From: Laura Gibbons <Laura.Gibbons@arun.gov.uk>
Sent: 21 December 2021 10:30
To: Planning.Responses <Planning.Responses@arun.gov.uk>
Cc: Simon Davis <Simon.Davis@arun.gov.uk>
Subject: FW: Planning Consultation on: Y/158/21/PL

Engineers Comments Regarding Surface Water Drainage

Description of Works: Demolition of existing dwelling and outbuildings and construction of 11 No dwellings (net increase 10 units) with access, landscaping and associated works (alternative to approved Y/121/19/PL). This site is in CIL Zone 3 and is CIL Liable as new dwellings & is a Departure from the Development Plan.

AND INFILTRATION SYSTEM

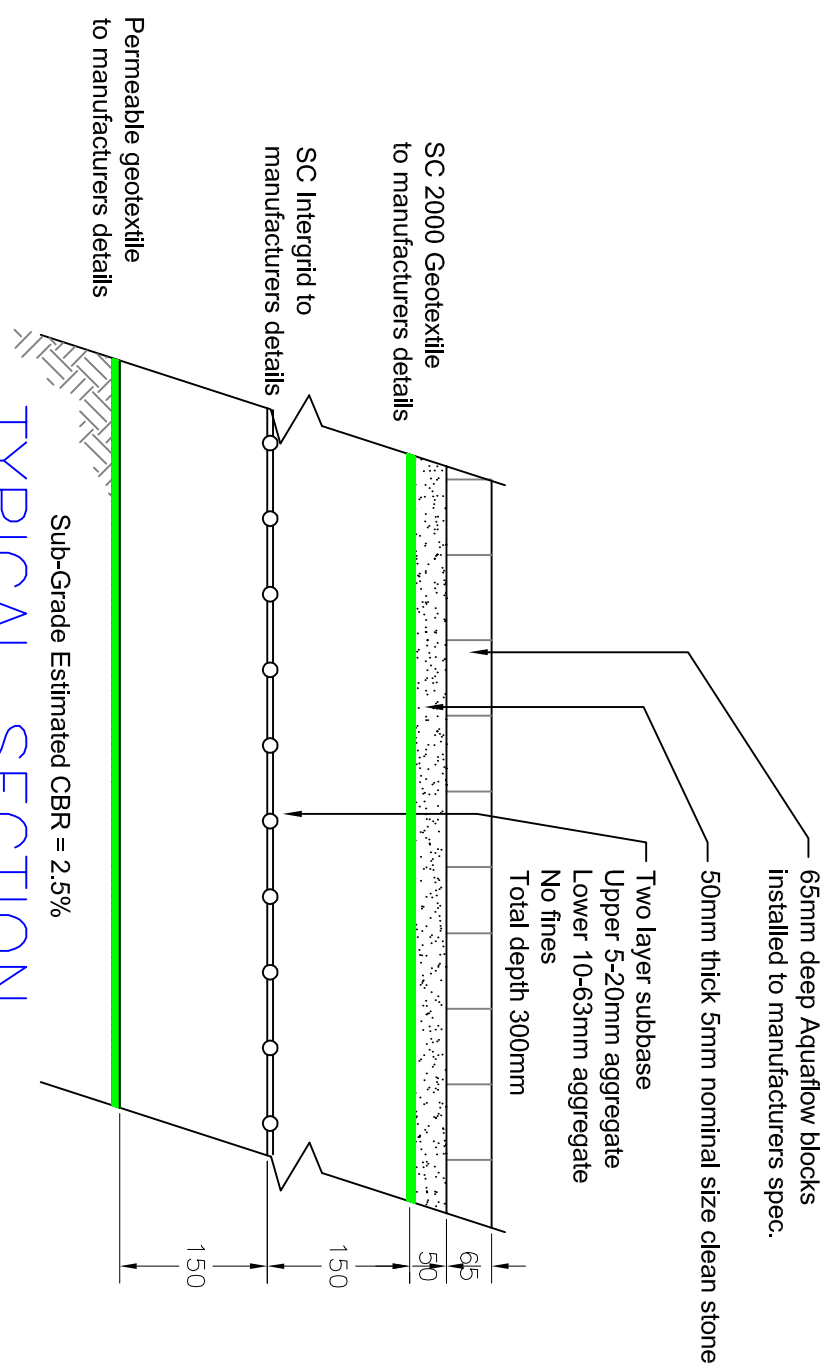
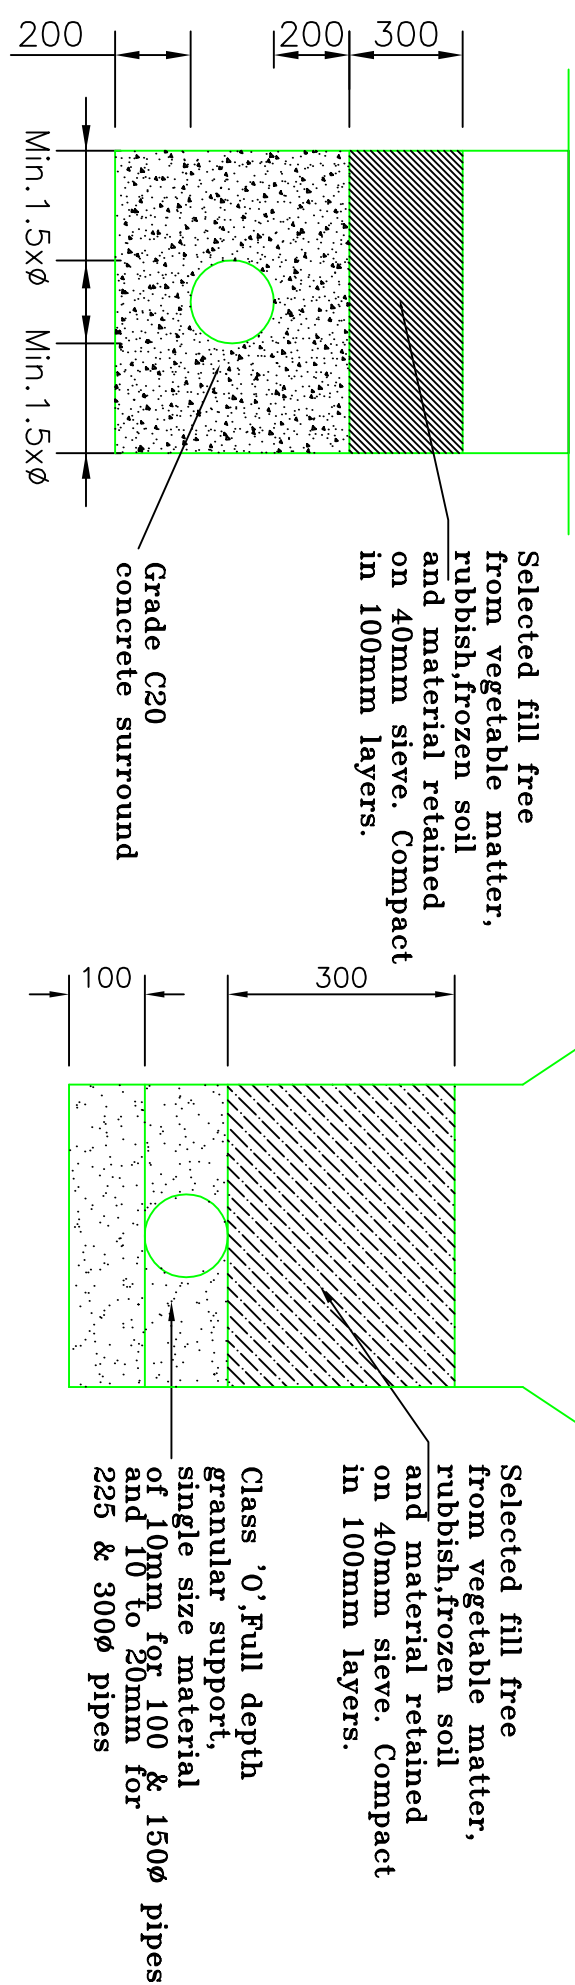
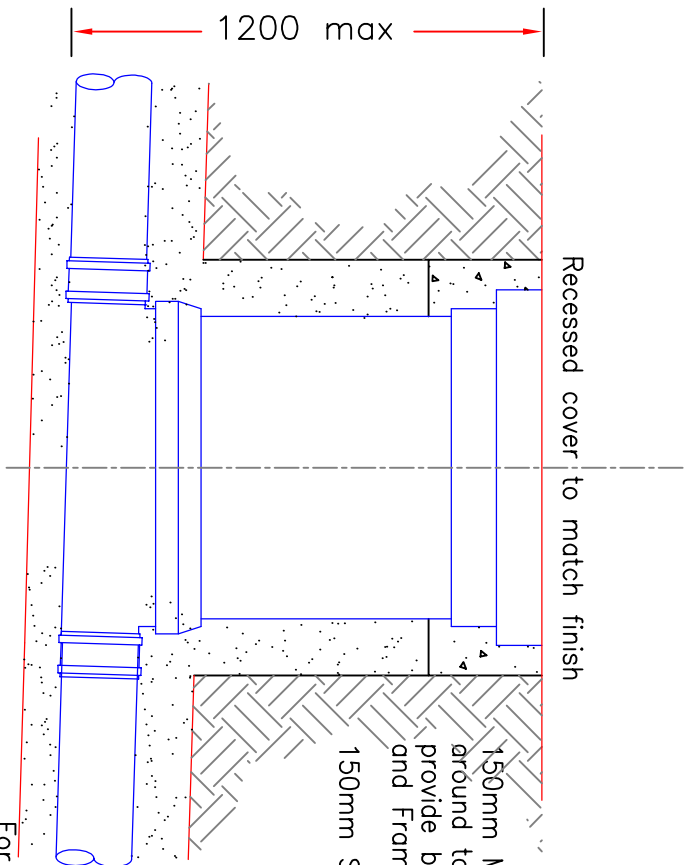
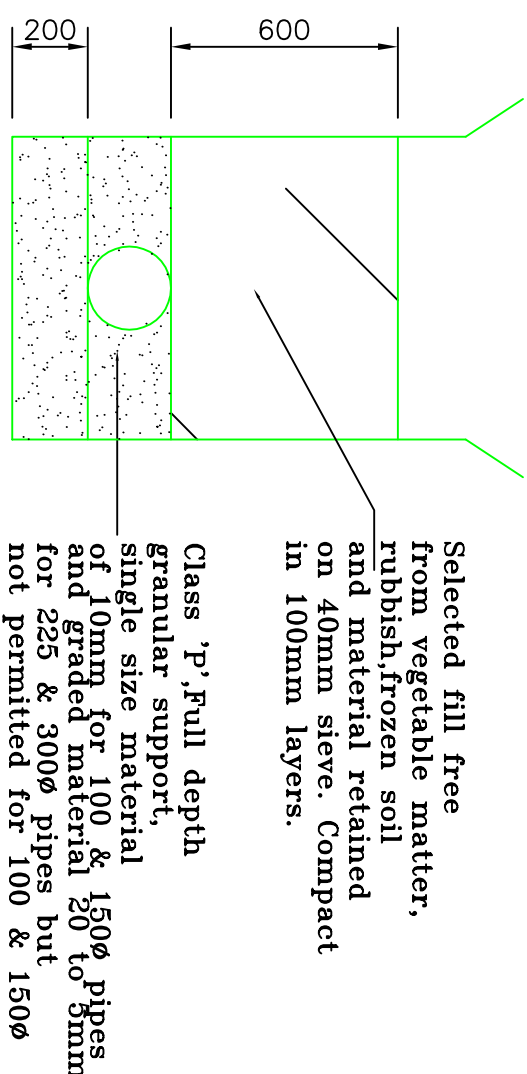
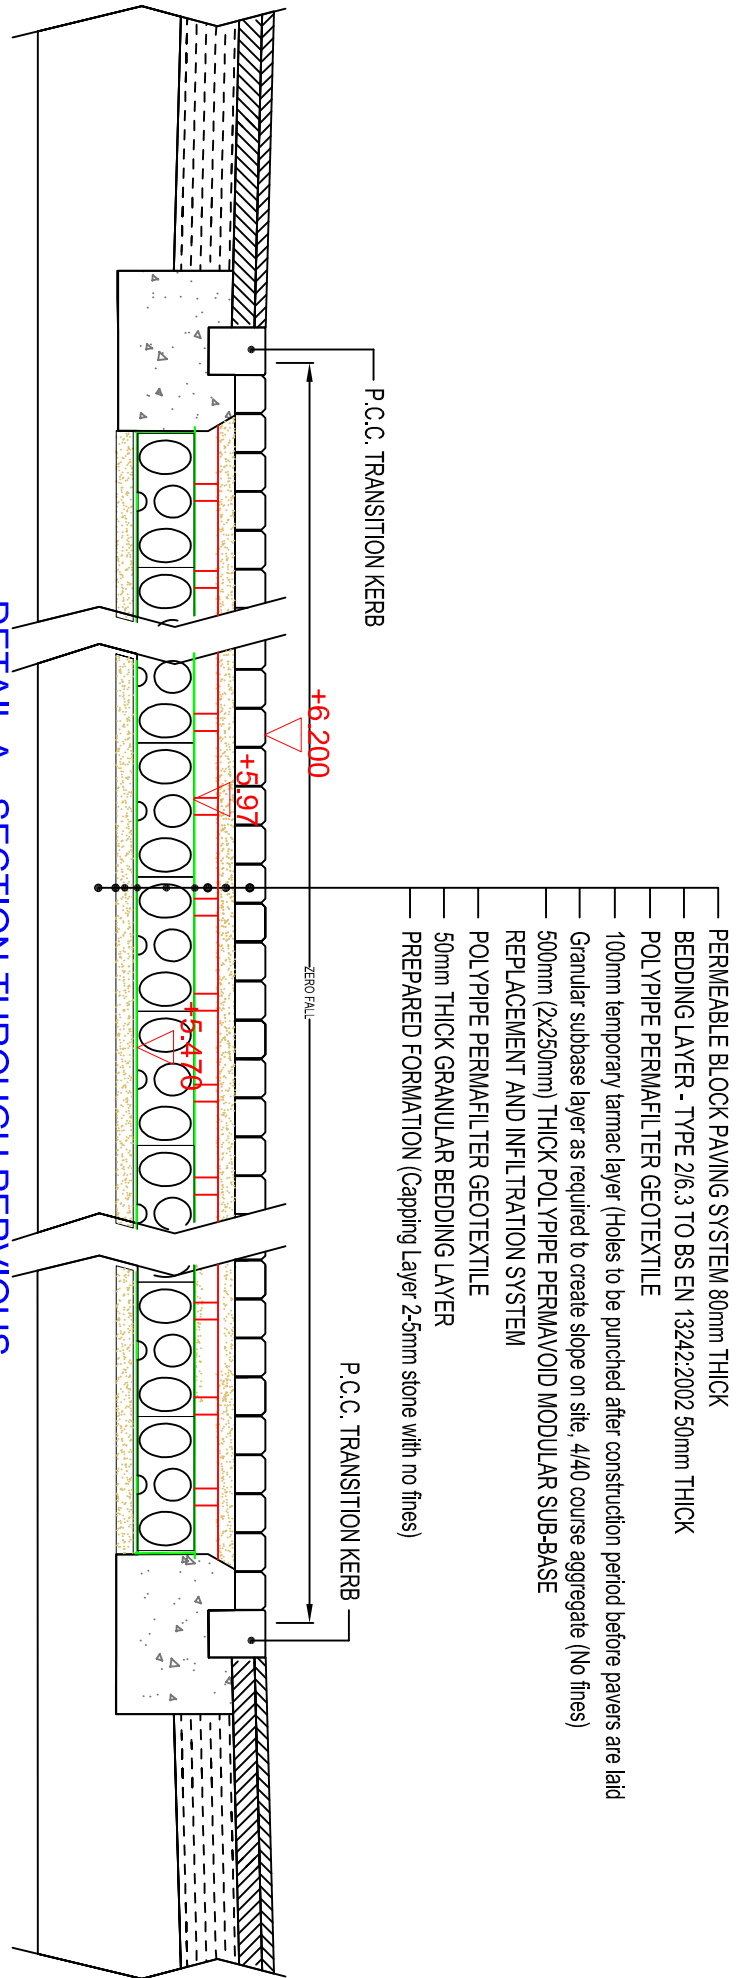
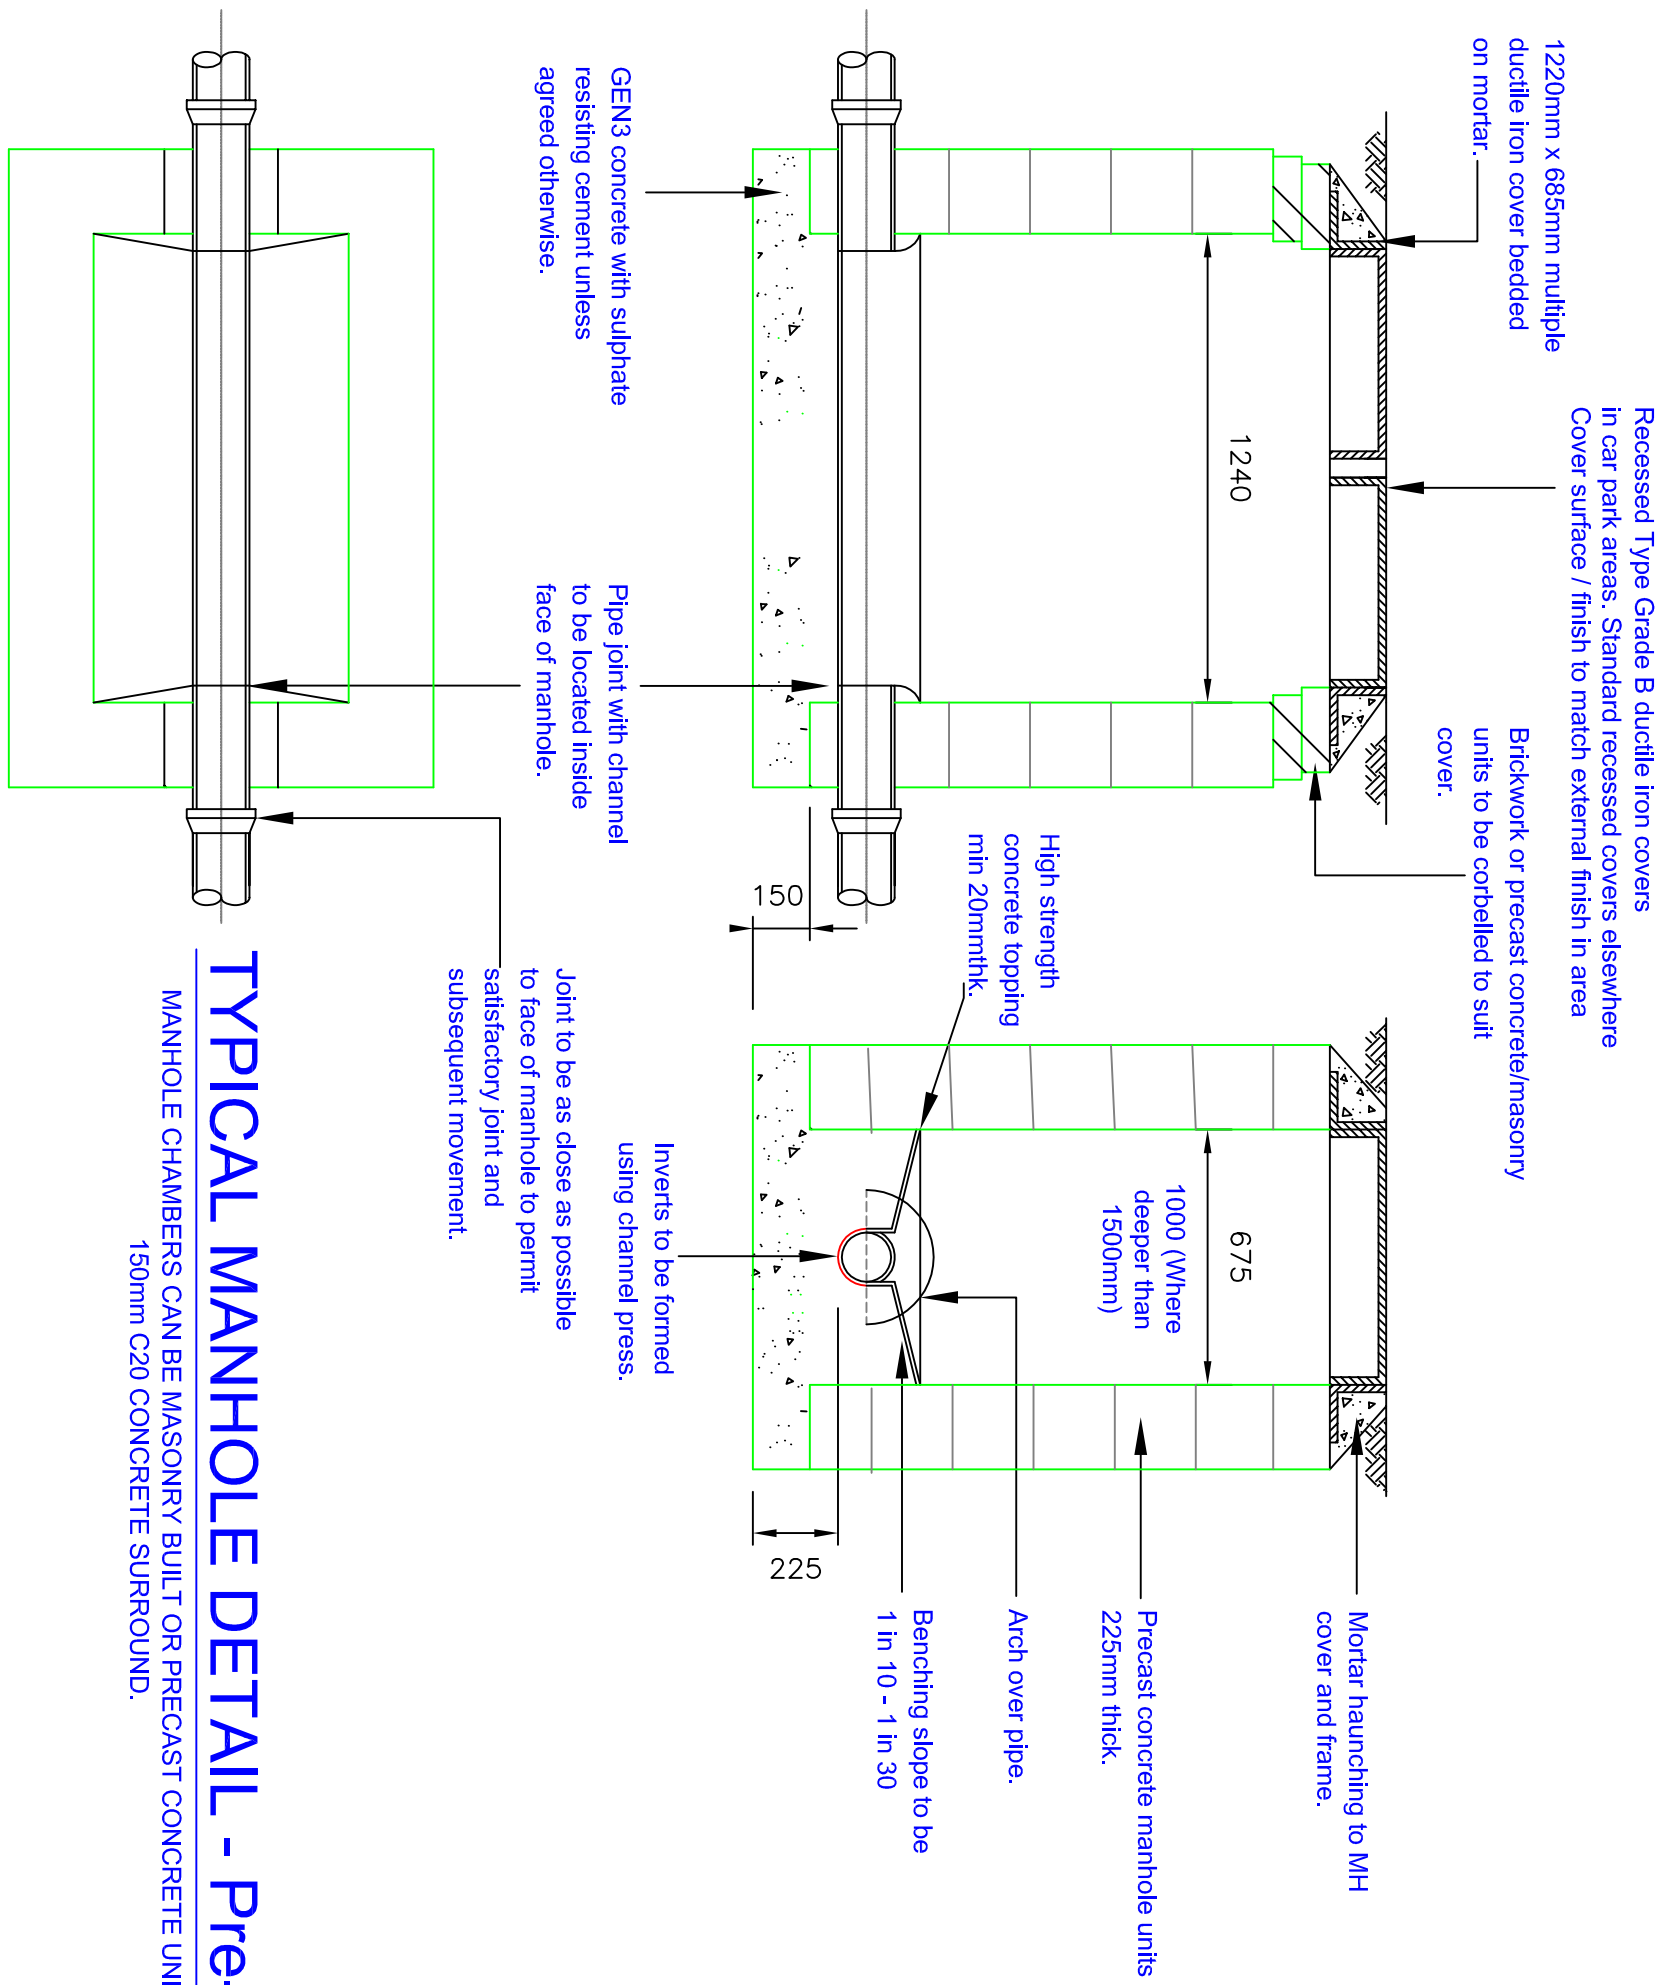
1. The majority of the permeable paving area is proposed to have an increased construction depth of 100mm, this is applied by reducing the formation level by 100mm.
2. Inlets to permeable paving for plots 1, 2 and 3 appear to be very closed to proposed buildings. Please ensure that inlets are a minimum of 5m away from buildings.
3. The levels around plots 9 and 10 appear to be higher (circa 350mm) than those previously proposed, we would like to highlight this to the case officer, and suggest a comparison is completed of FFLs.
4. We request that the make up of any capping material below the permeable paving is clearly defined. This must be a permeable material.
5. The management manual should contain a copy of the drainage layout and construction details within an appendix.
